**RE: Conexus Business Park Phases 2 & 3 Preliminary PUD Plan  
Response to First Comment Letter**

This letter responds to your December 23, 2021 review letter for the subject project. Responses to review comments are shown in **RED** below.

### **Preliminary PUD Plan Comments**

Figure 4

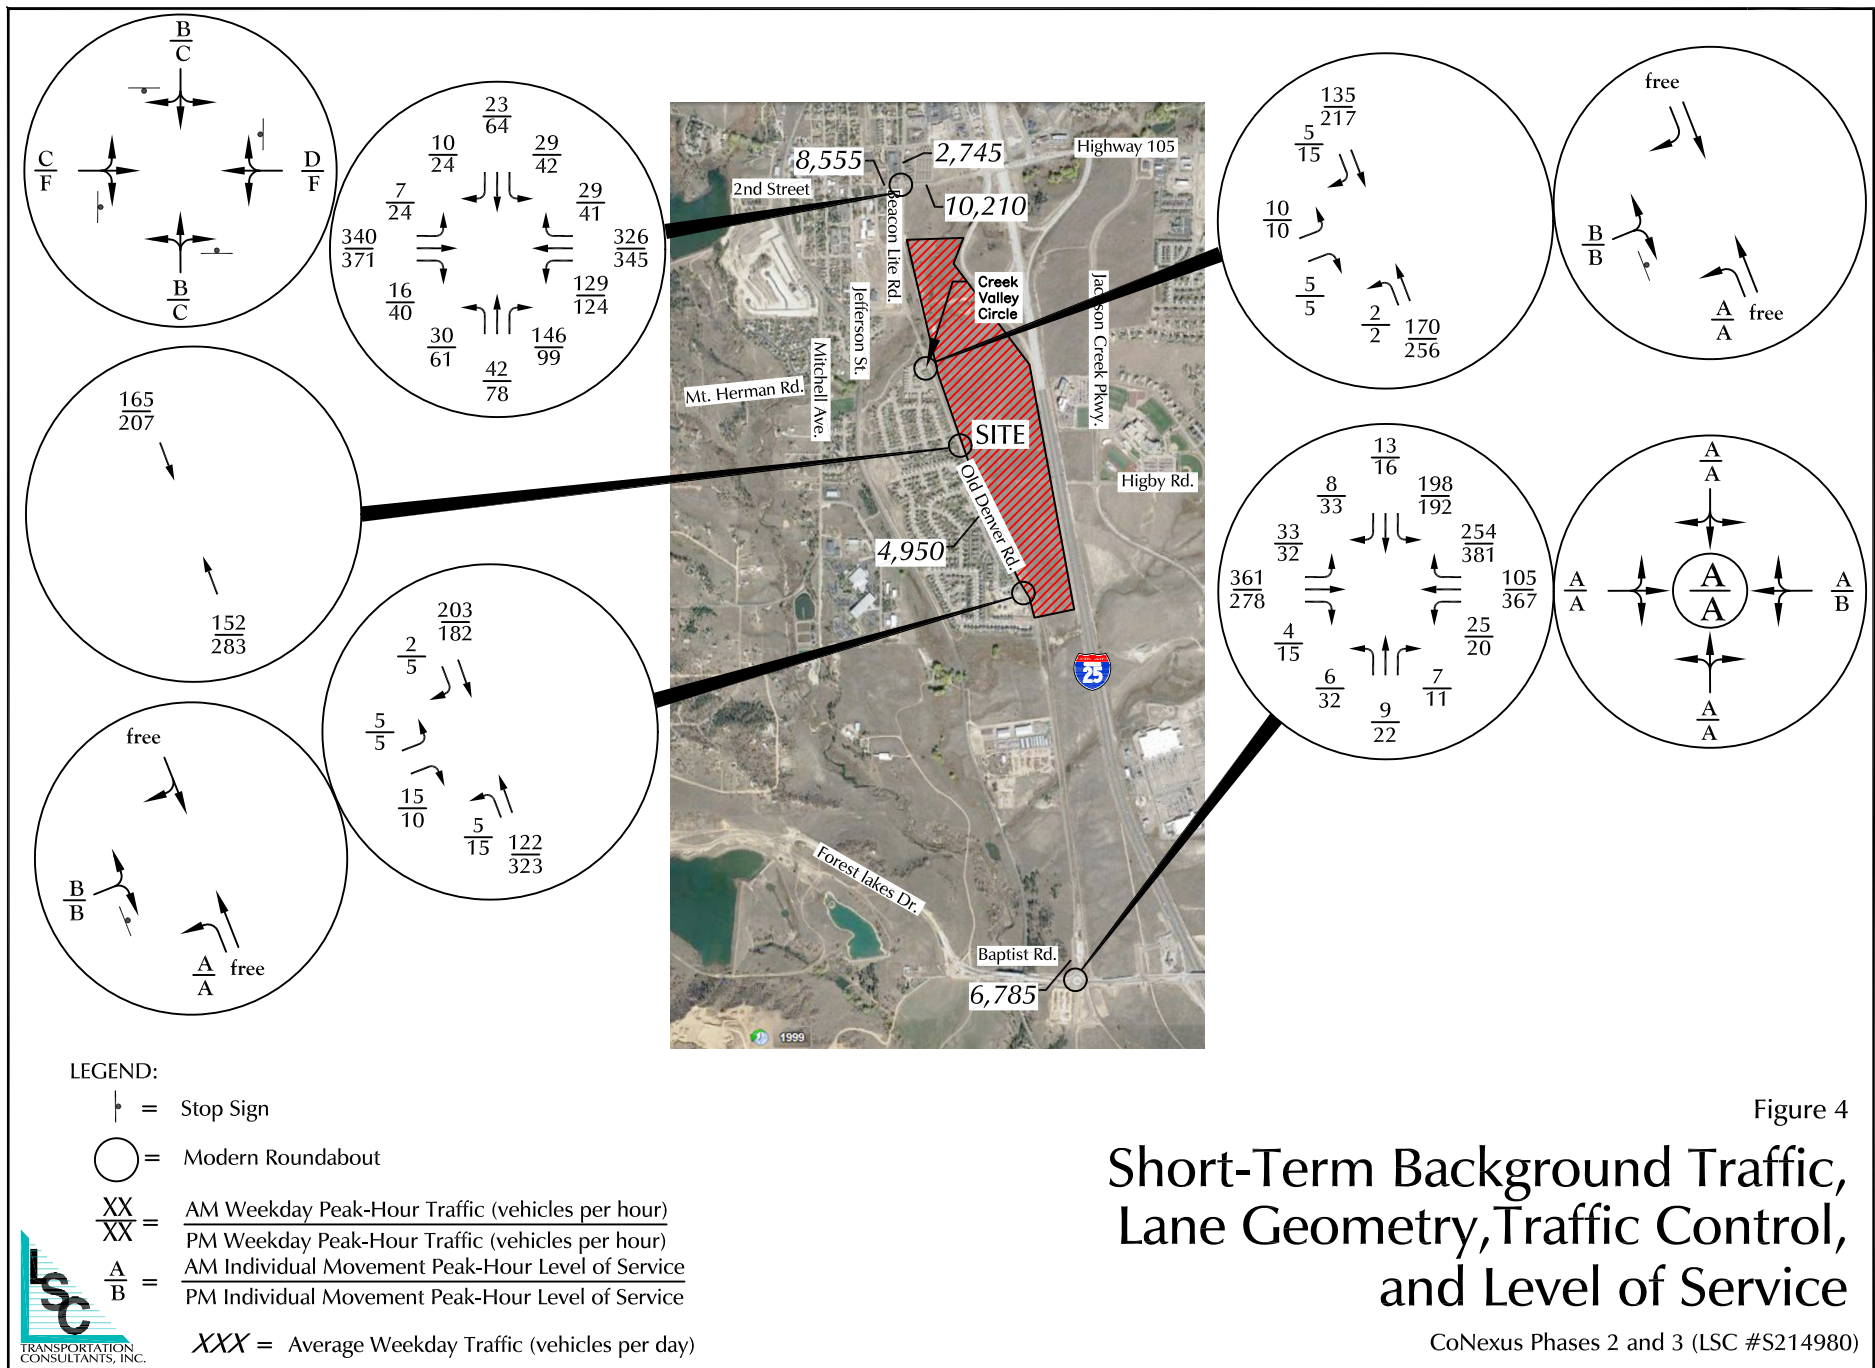
**RESPONSE:** Revised as requested.
8. Figure 4, the WBTH AM volume (105 veh) at Baptist does not match the volumes shown on Figure 8. Please verify which number is correct, that it was analyzed properly, and revise as needed.

**RESPONSE:** The background traffic volumes at Baptist have been revised based on traffic counts conducted in January 2022.
9. Figure 7 shows 8/17 pass-by trips for the WBRT. Please update to 2/6.

Figure 10  
2040 Total Traffic Volumes

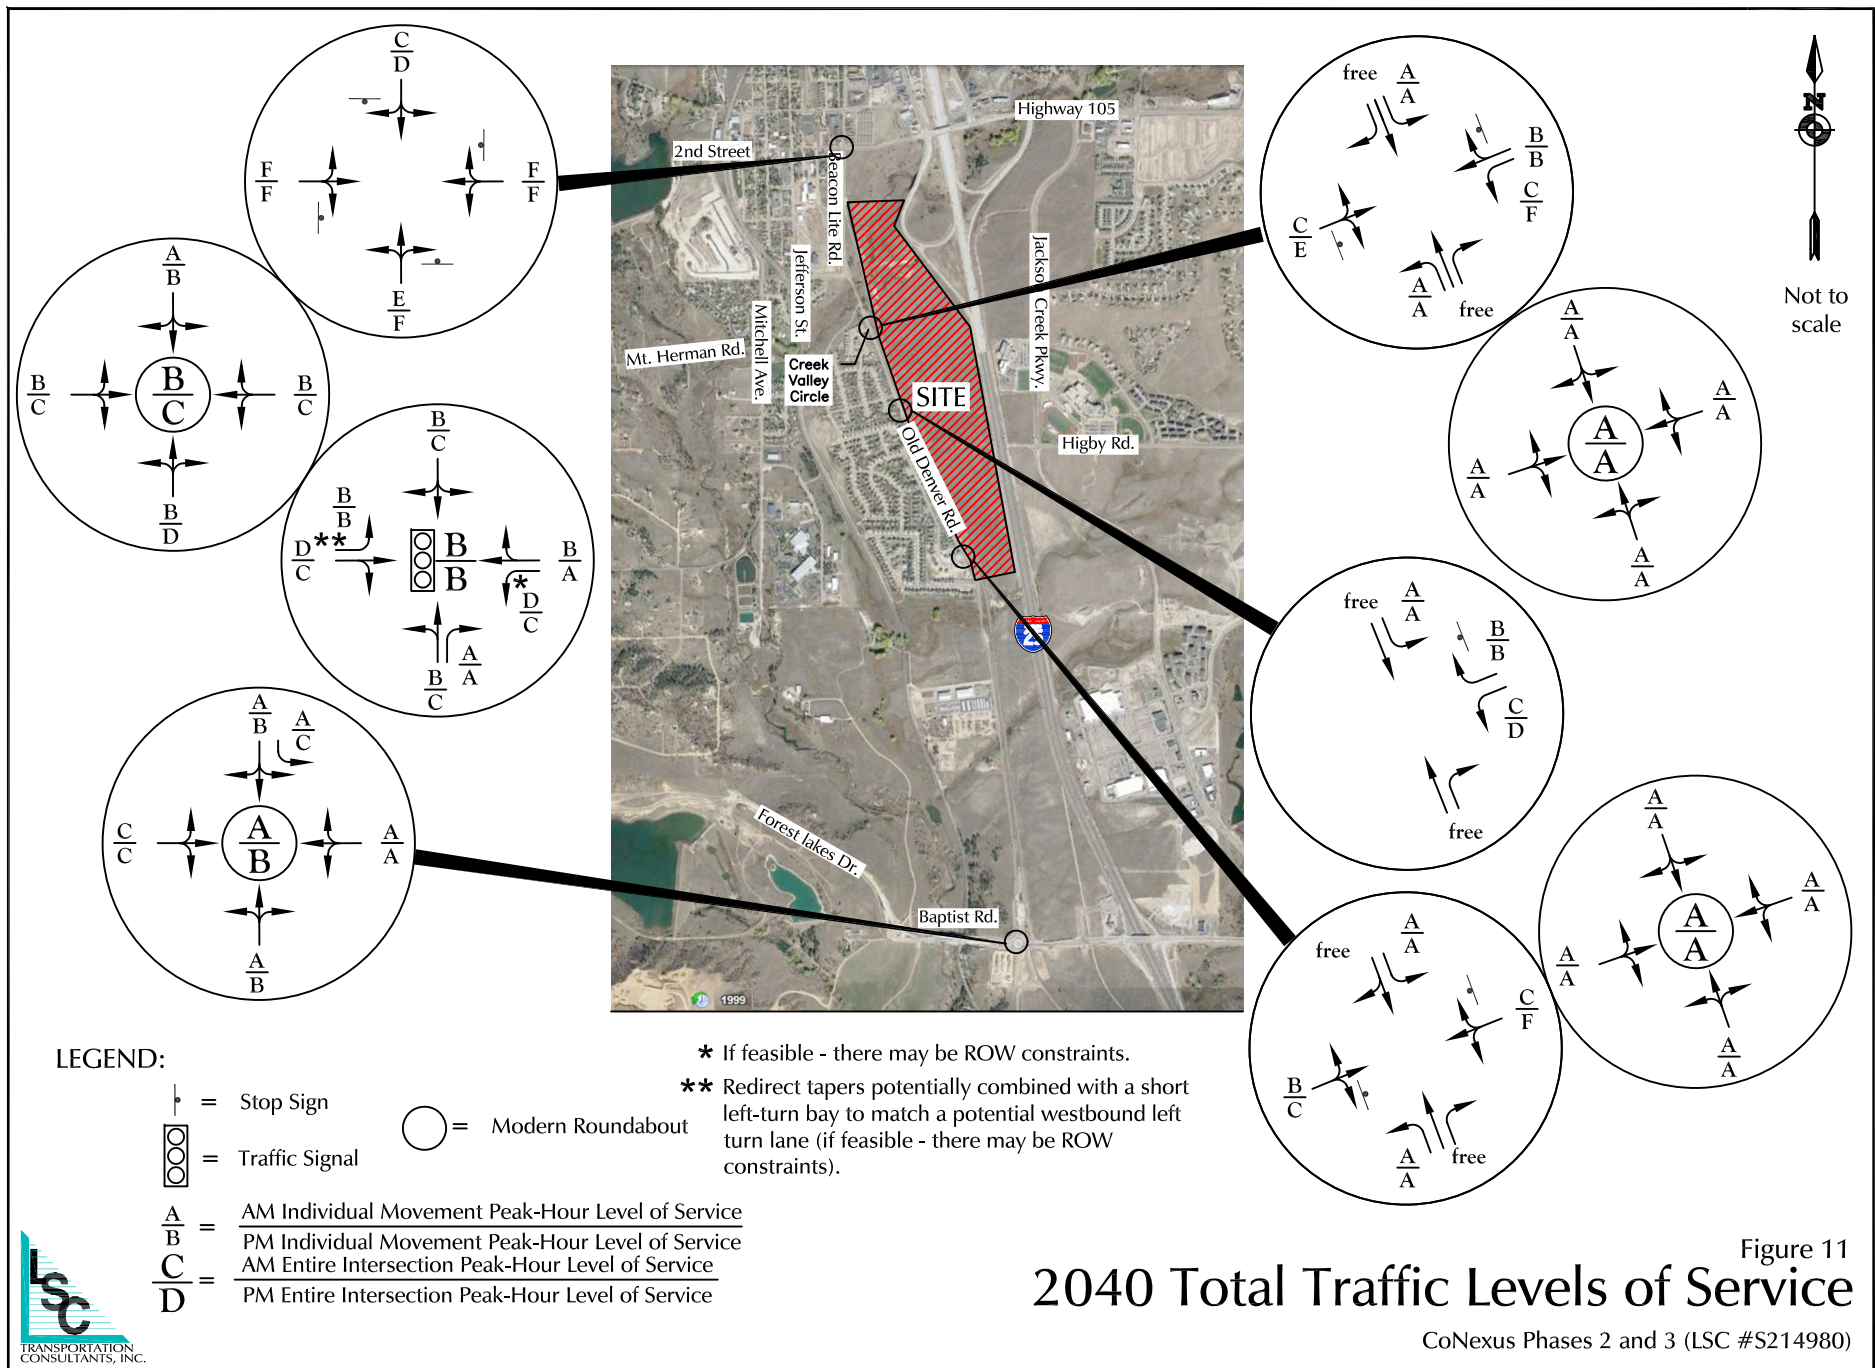
10. Figure 10, EBRT at south access shows 15 veh in AM when background shows 5 veh. Please verify which number is correct, that it was analyzed properly, and revise as needed.

11. Figure 10, NBTH at Baptist Rd shows 31 veh in the AM. I think it should be 17 veh. Please verify which number is correct, that it was analyzed properly, and revise as needed.

**RESPONSE:** This comment is no longer applicable based on the current access plan with Old Denver Road realigned through the site.

**RESPONSE: The background traffic volumes at Baptist have been revised based on traffic counts conducted in January 2022.**
12. Please add WB right-turn bypass lane symbol to Figure 11.

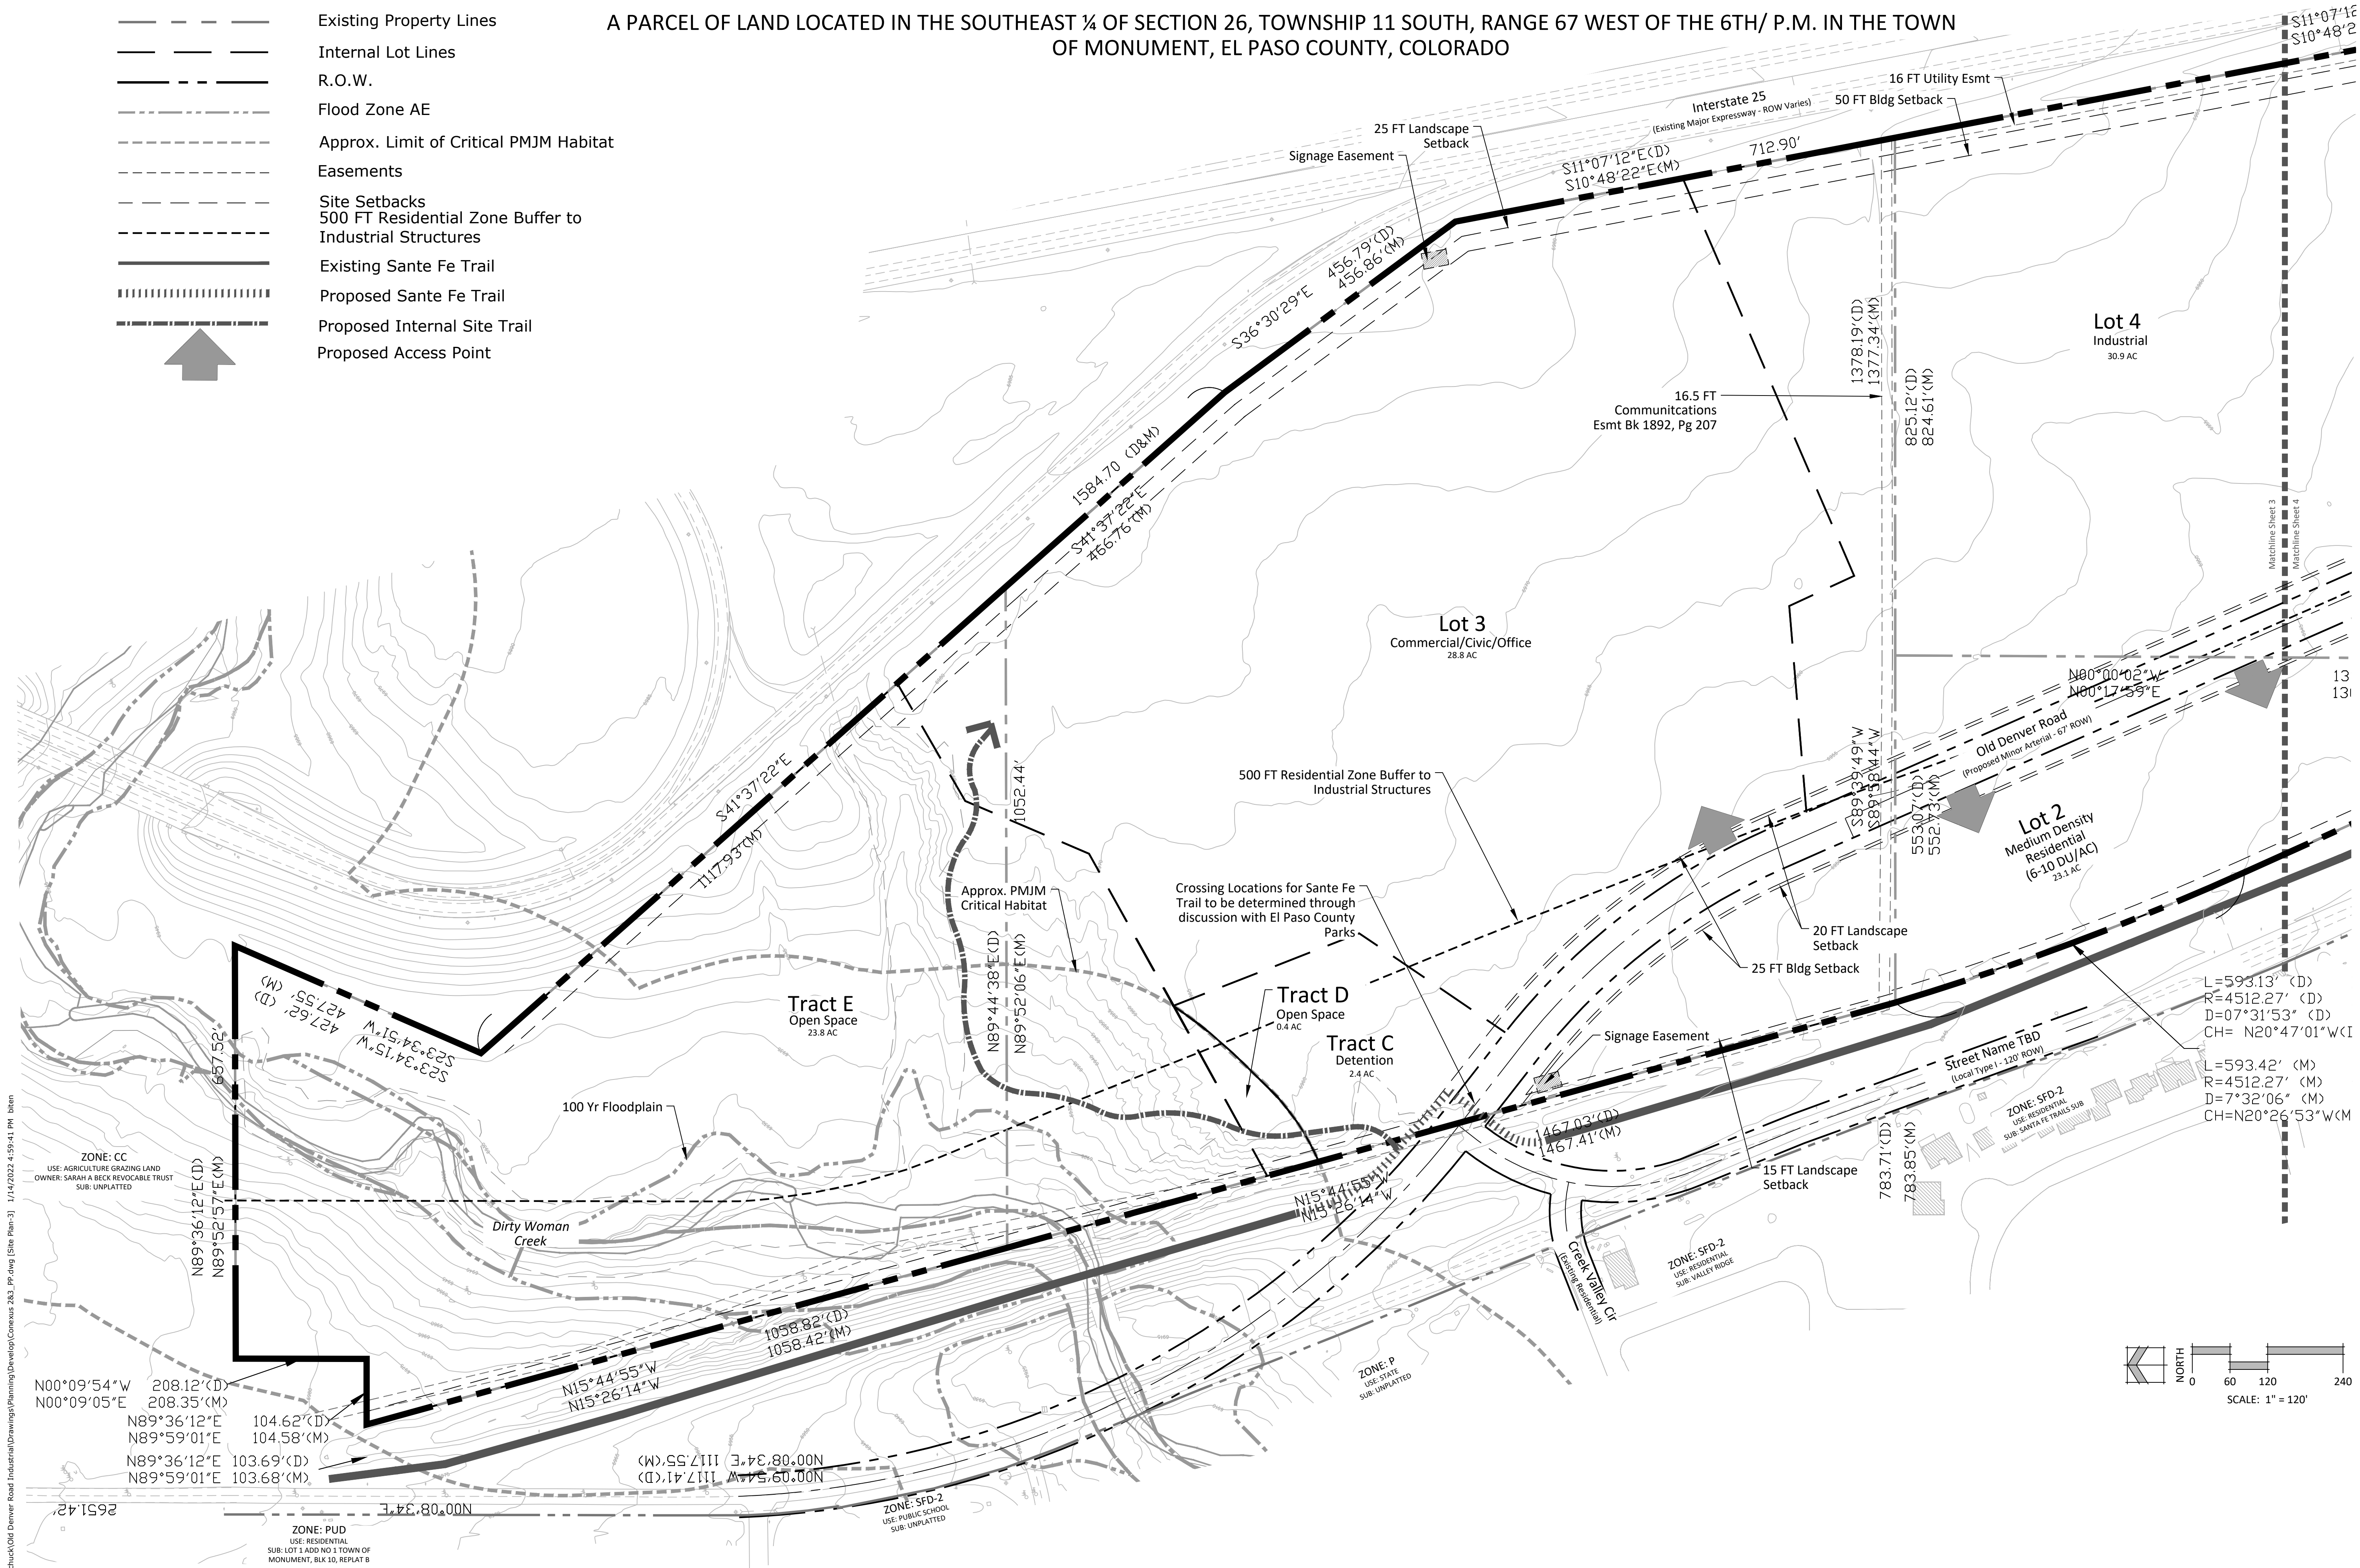
Sheet 1:

The number of residential units in the land use chart does not match what is analyzed in the traffic report. Please make sure in the final site plans that these match.

Indicate pavement thickness on the Local Type II cross section to support industrial traffic. Also note that 15' travel lanes are required for a Local Type II.

**RESPONSE:** The numbers on the Preliminary Plan are correct and the traffic report has been revised accordingly.

**RESPONSE:** Plans revised and this road type has been deleted
